WEST SUSSEX COUNTY COUNCIL CONSULTATION

TO:	Arun District Council FAO: Simon Davis
FROM:	WSCC - Highways Authority
DATE:	1 September 2020
LOCATION:	The Former Ship Inn Aldwick Street Aldwick PO21 3AP
SUBJECT:	AW/197/20/PL Variation of conditions 8-concerning hours of deliveries & 10 types of vehicles making deliveries following AW/211/14/PL. This application is in CIL Zone 4 (Zero Rated) as 'other development'.
DATE OF SITE VISIT:	n/a
RECOMMENDATION:	No Objection
S106 CONTRIBUTION TOTAL:	n/a / £ See below for breakdown.

Articulated Deliveries Vehicle
with Refuse Vehciles Passing
scale 1:500 @ A1

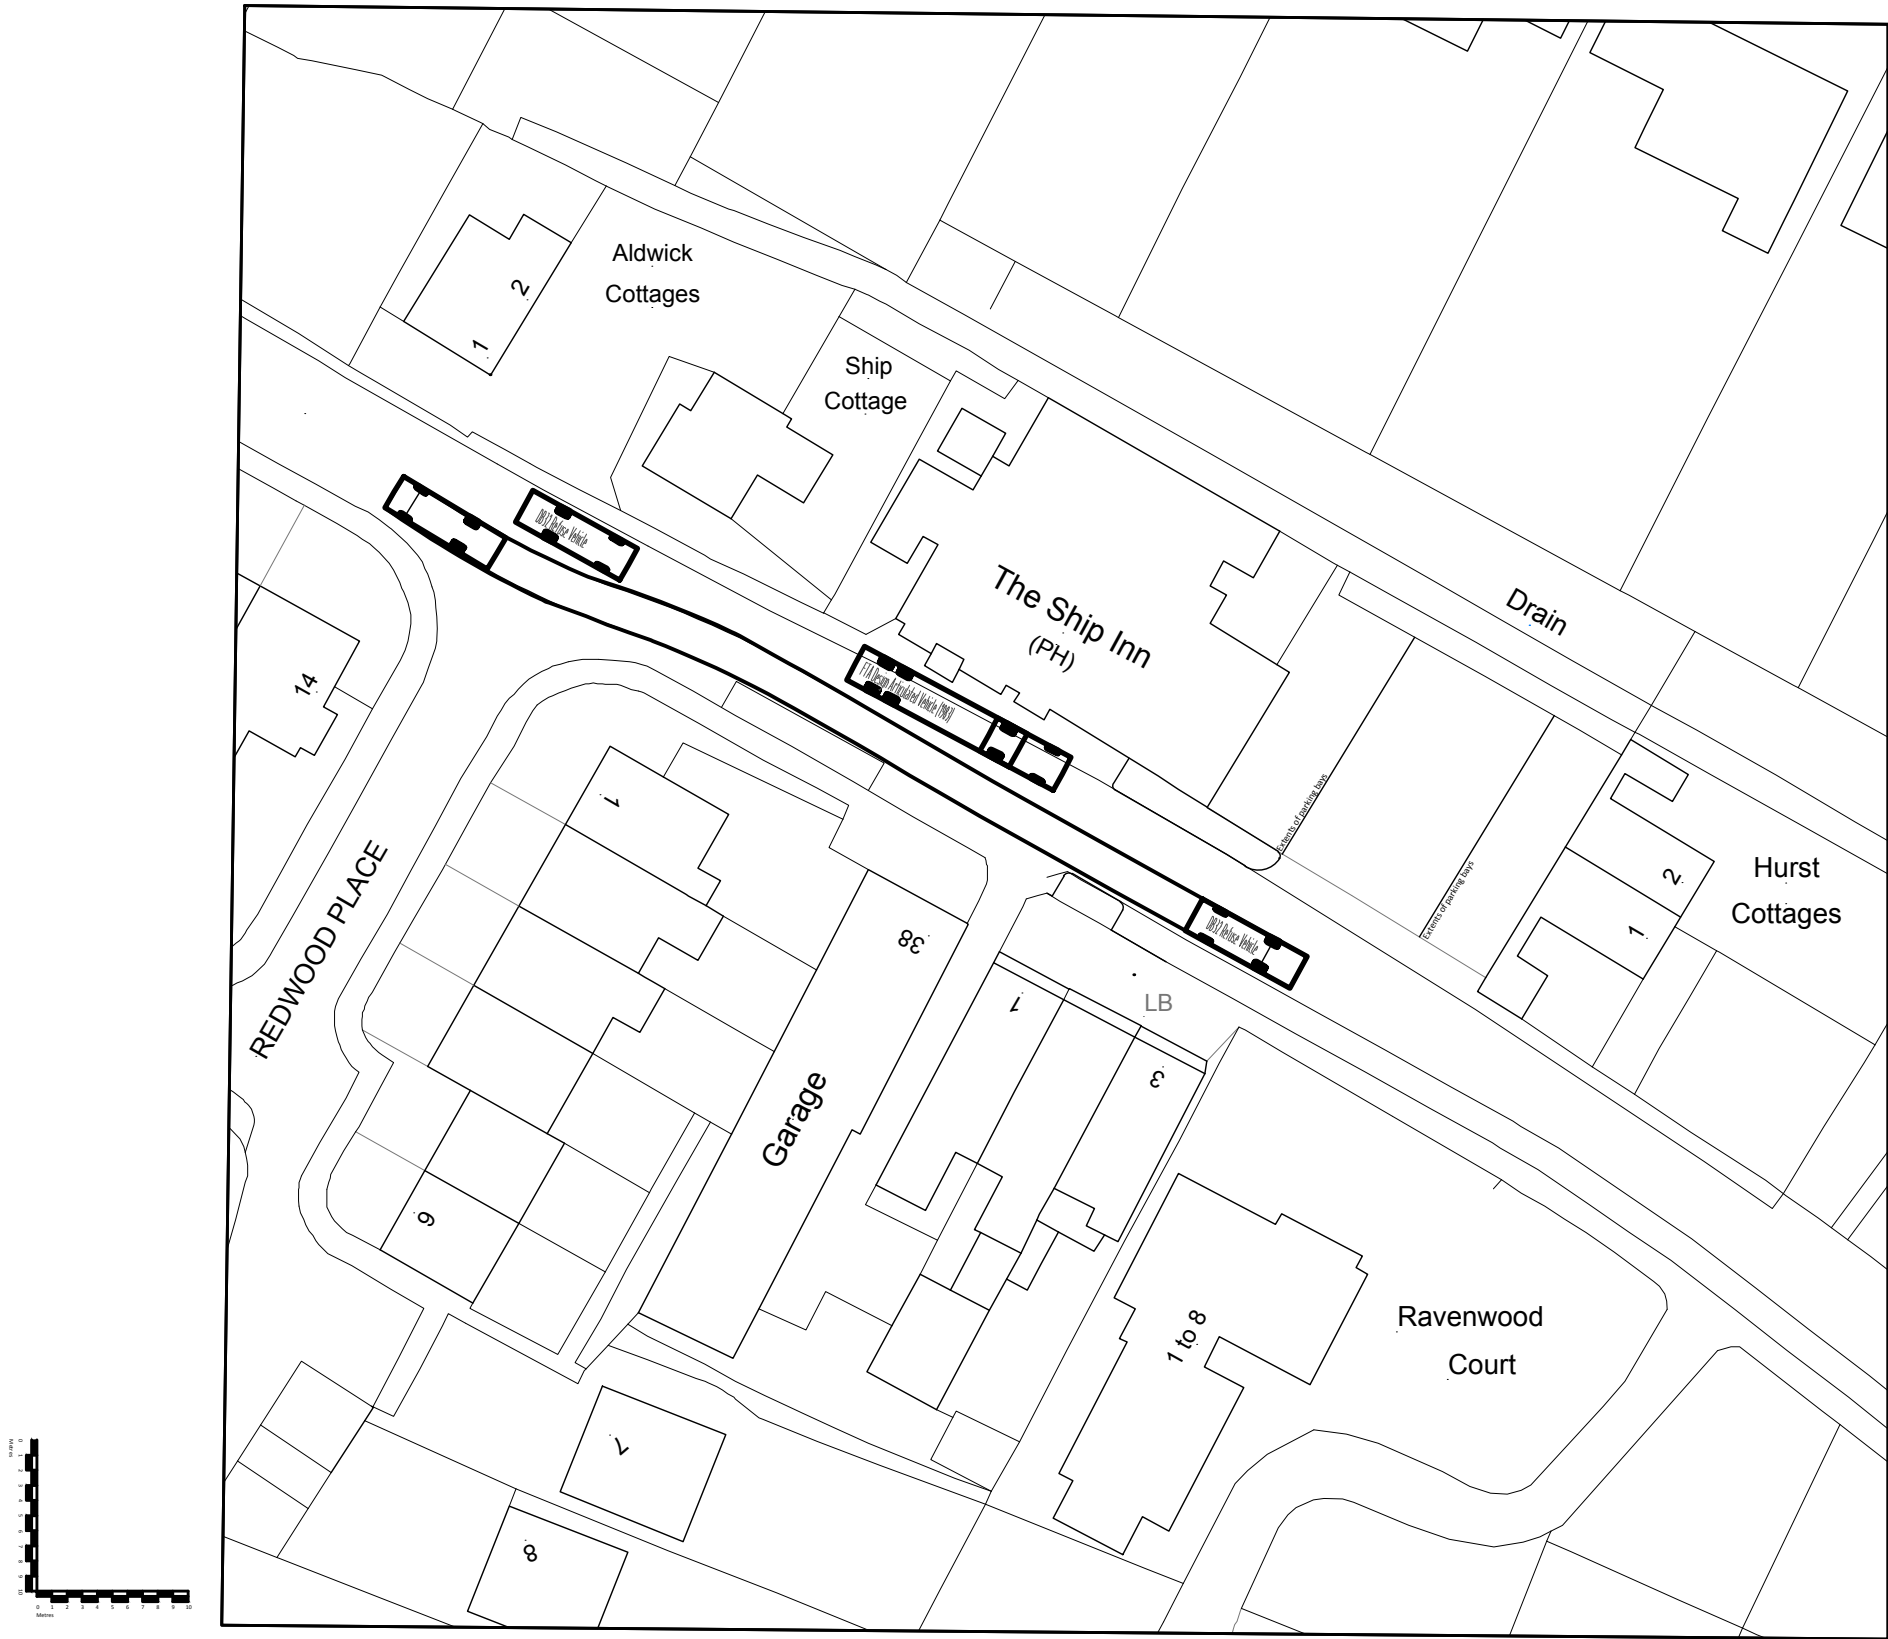
Swept path diagrams show a combination of movements and vehicle types to demonstrate a rigid vehicle, or articulated vehicle can load and unload in the highway without causing any significant harm to the operation of the highway network.

It is noted the largest vehicle used in the delivery management plan would be an articulated vehicle with dimensions of 2.6m in width and up to 16m in length. It has been said this will only be used on rare occasions and given the street dimensions would still allow a car or refuse truck to pass freely. Based on the submitted highway plan which shows the dimension of the road at three points, it is
